Arun District Council
Development Control
1, Arun Civic Centre Maltravers Road
Littlehampton
West Sussex
BN17 5LF

Our ref: HA/2011/111270/01-L01
Your ref: LU/18/11/
Date: 18 February 2011

**ERECTION OF 2 NO. 3 BEDROOM TOWN HOUSES
R/O 27-29B SURREY STREET LITTLEHAMPTON, WEST SUSSEX BN17 5BD**

GROUND FLOOR PLAN

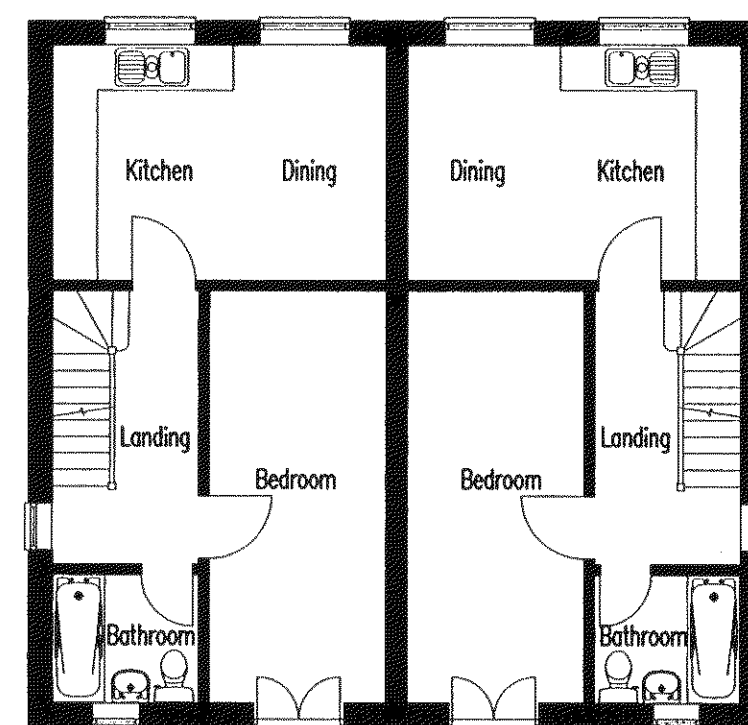
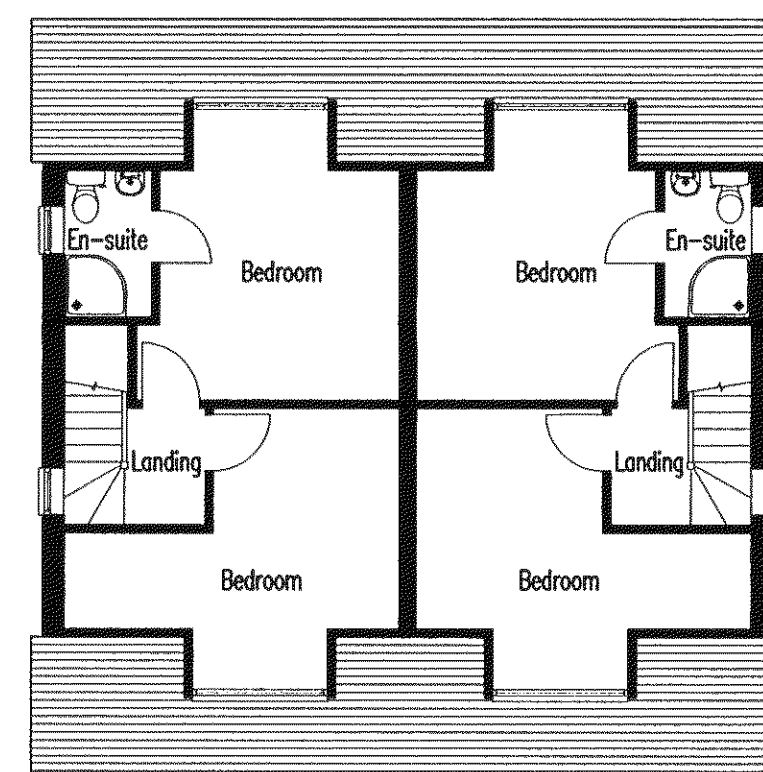
In particular, the submitted FRA fails to provide any information on predicted flood levels. This information is necessary to show the proposed mitigation of raised finished floor levels is sufficient to ensure the safety of the development and its occupants over its lifetime. Please note that where it is proposed to raise floor levels, this information should be given relative to Ordnance Datum.
